Ask for:	Erika Davies
Telephone:	01832 742207
Planning Services	Planning.enc@northnorthants.gov.uk
Our Ref:	NE/21/01069/FUL
Your Ref:	PP-09997866
Date:	13 July 2021

Proposal : **Single storey ancillary accomodation to replace existing single garage. at Pond Yard 32 Back Lane Collyweston Northamptonshire PE9 3PJ .**

Drawing  
**EXISTING**  
Plans & Elevations

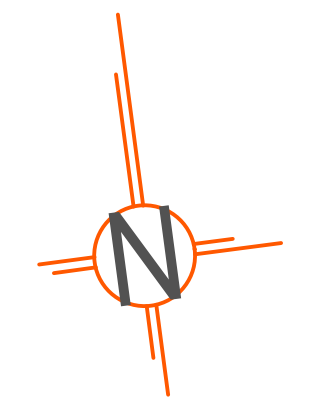
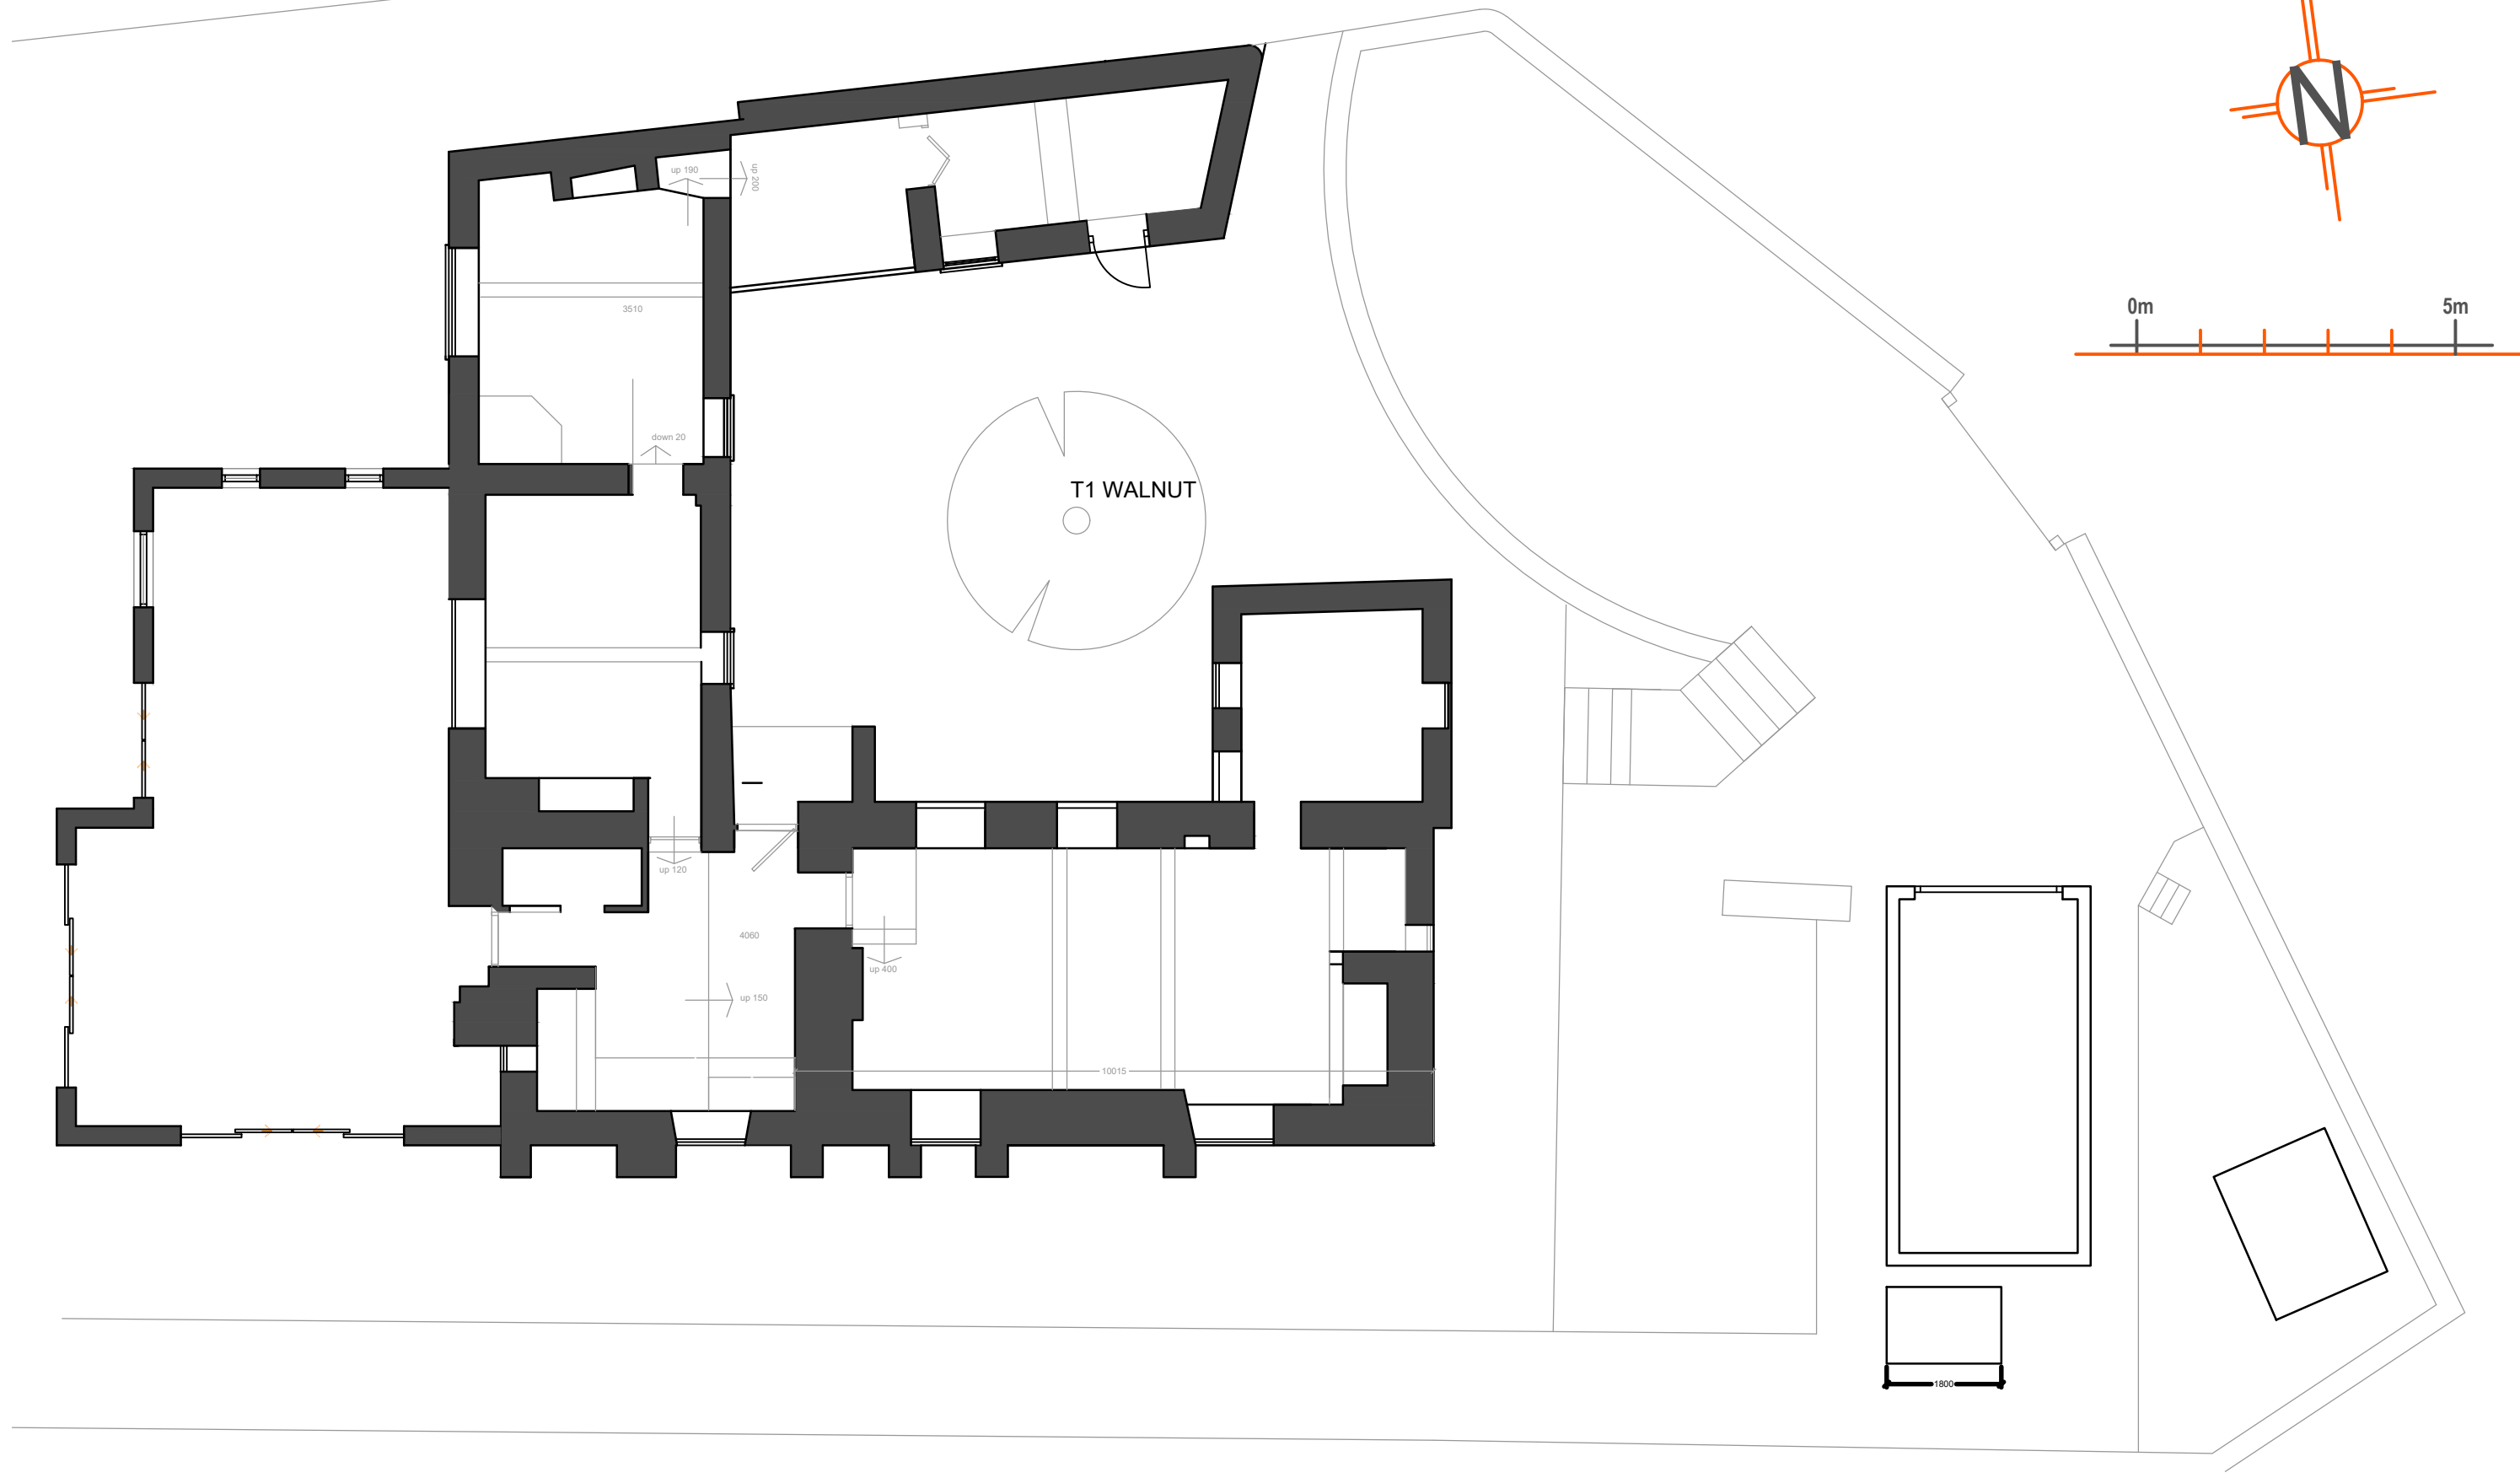
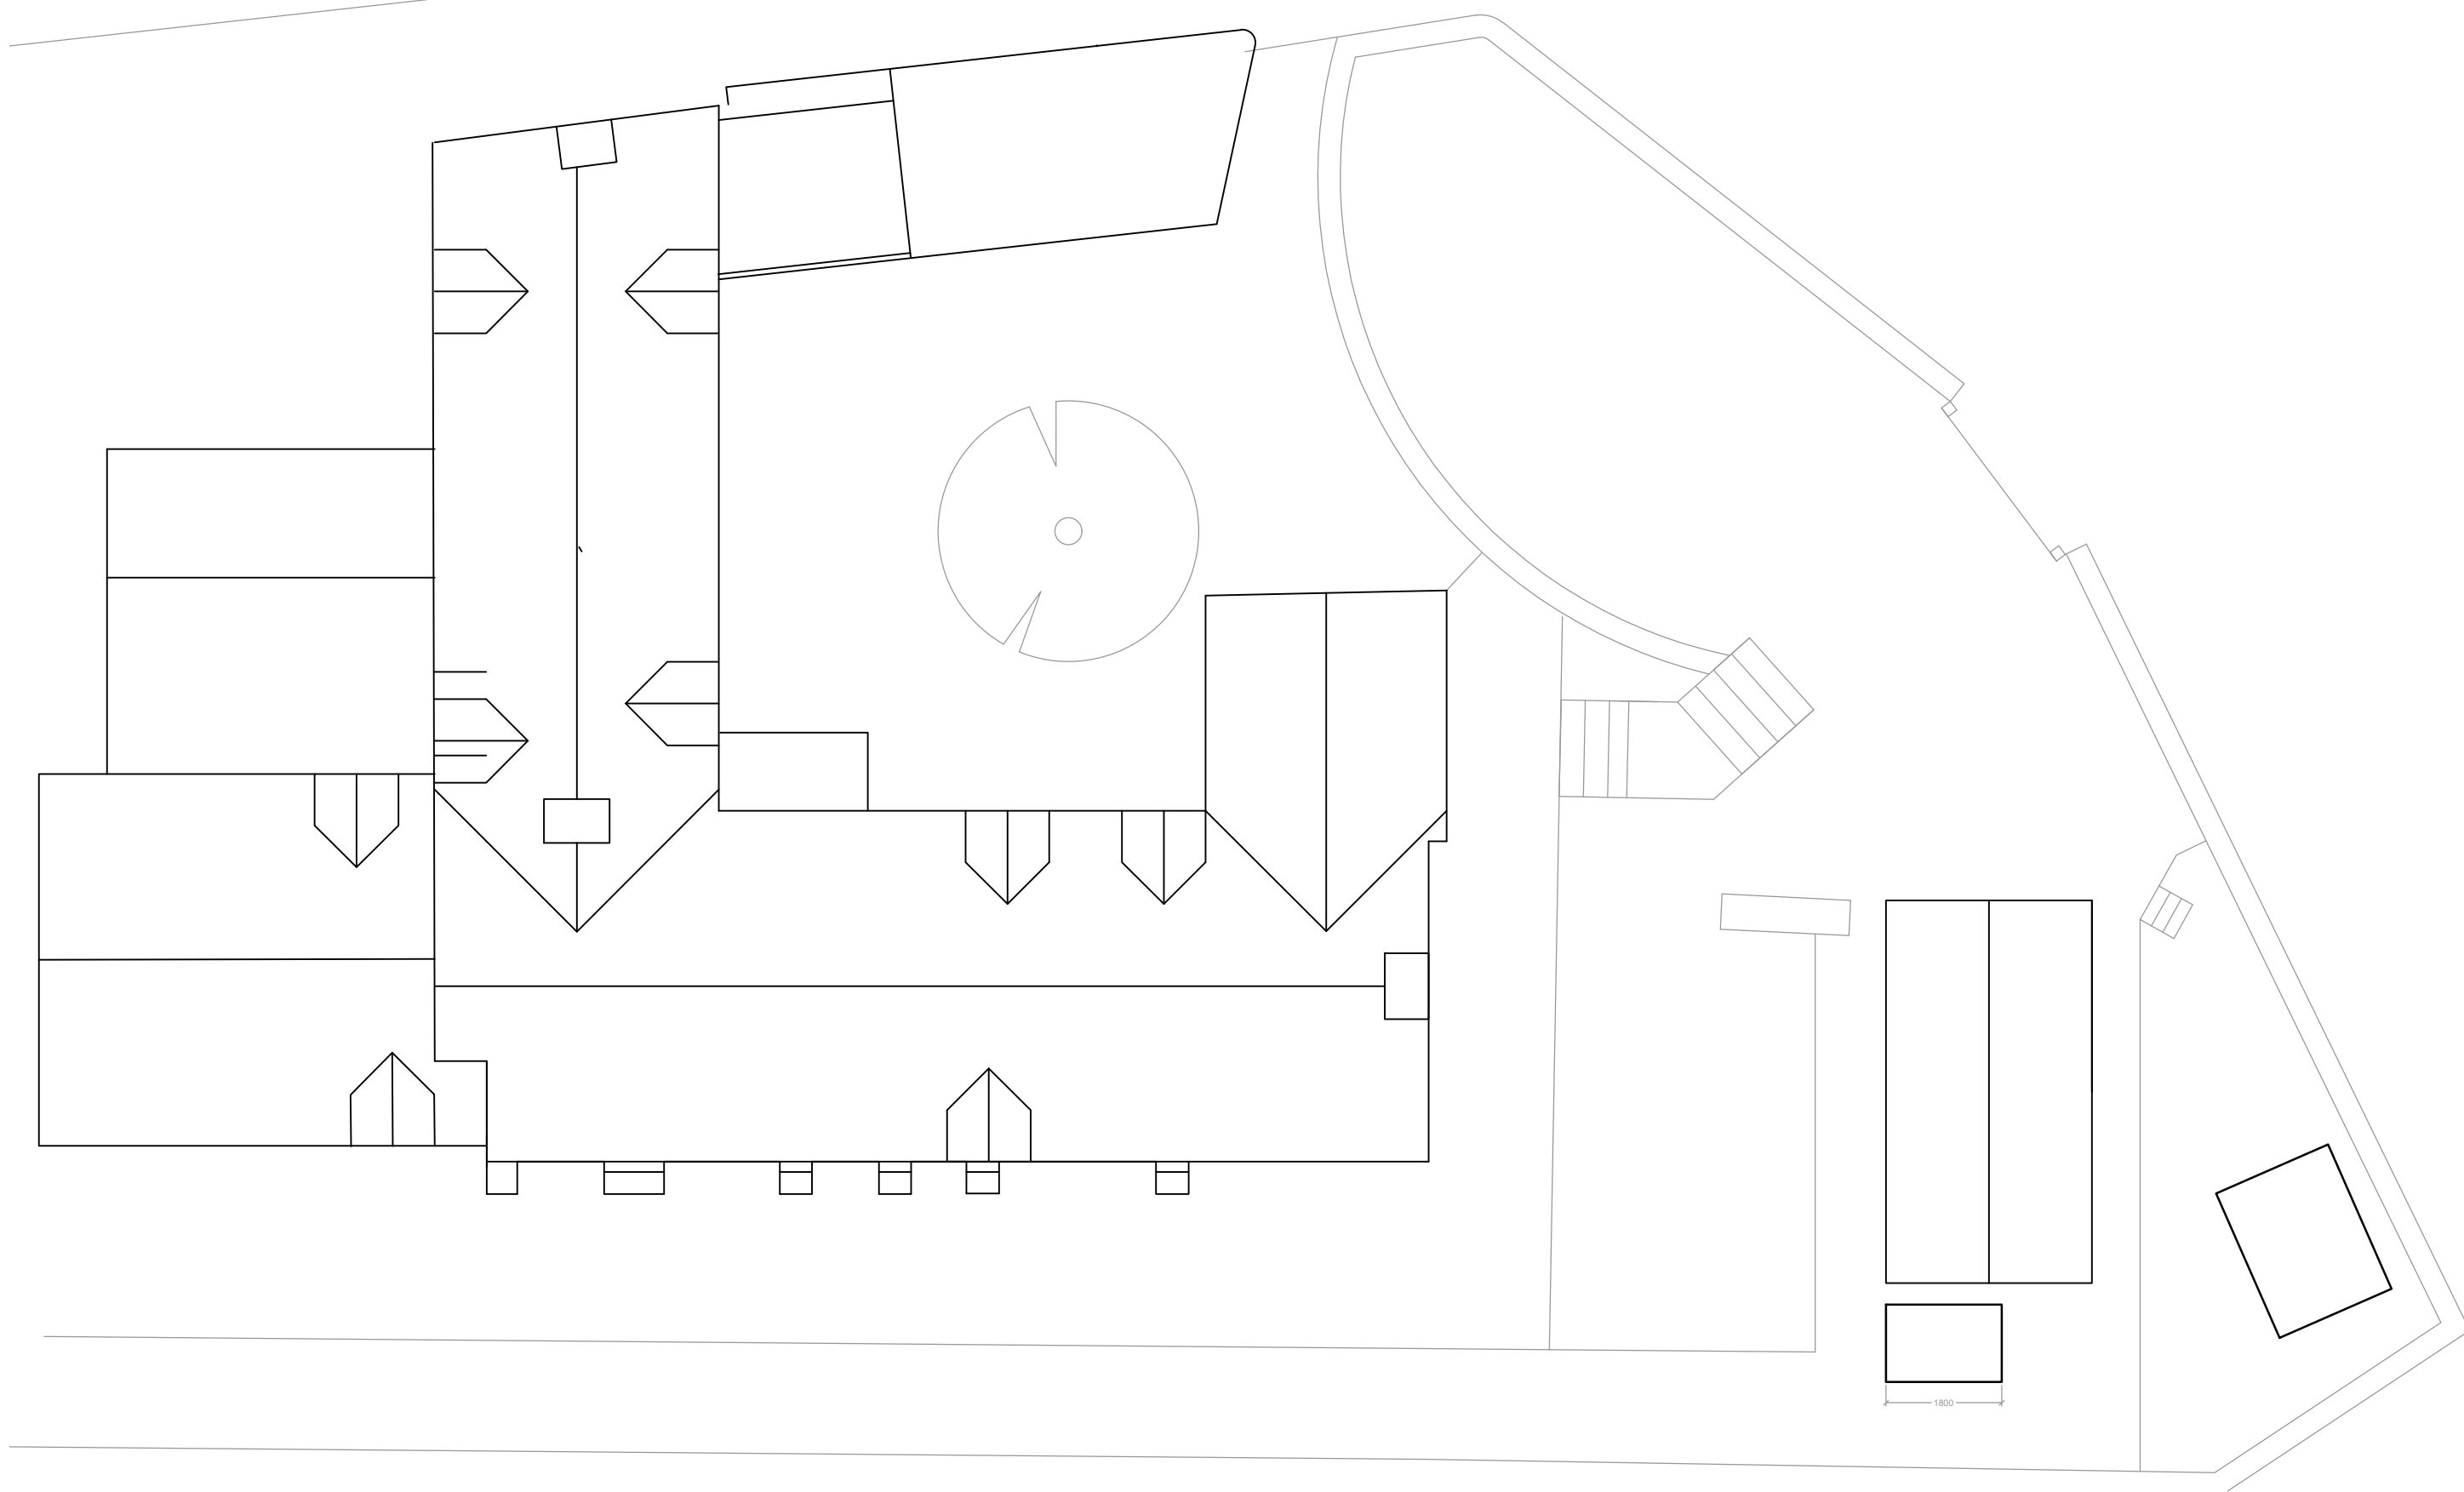
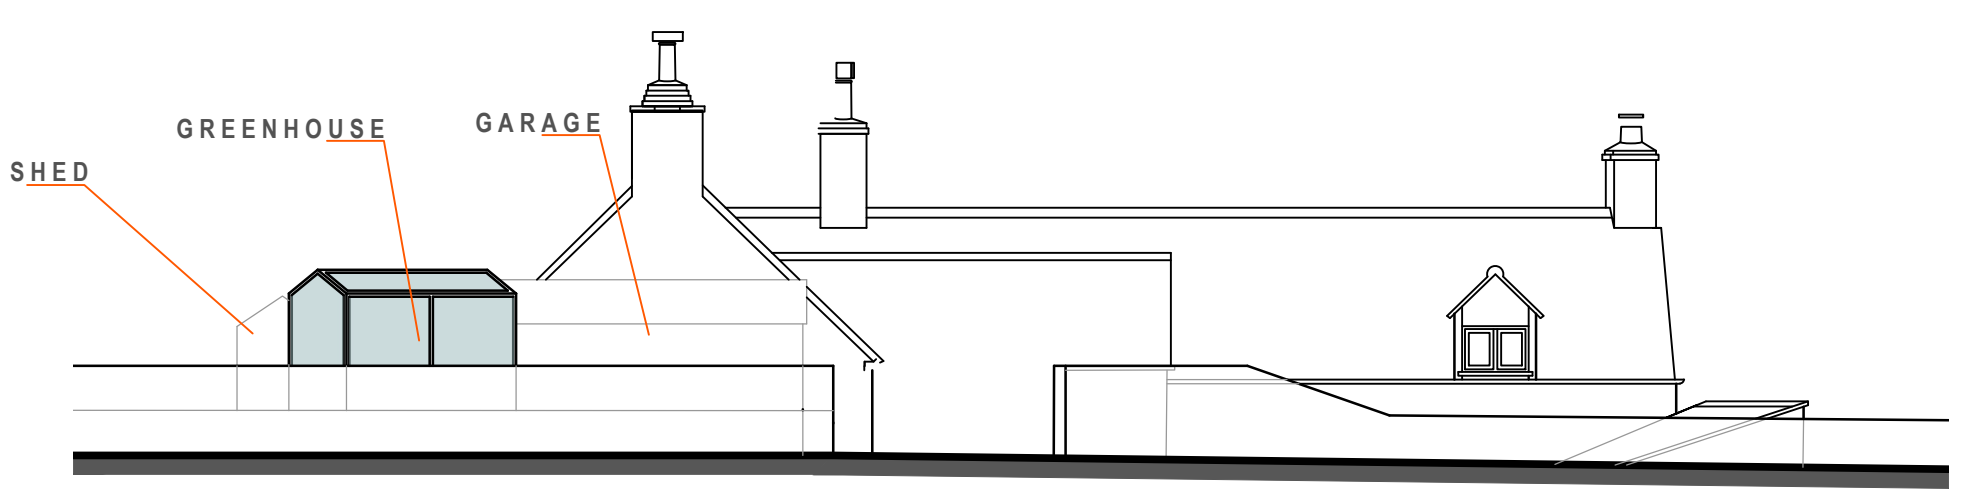
Please provide amended drawings including all relevant dimensions of the proposal:

- Dimensions for the existing and proposed floor plan
- Dimensions for the existing and proposed elevations annotated with all height dimensions
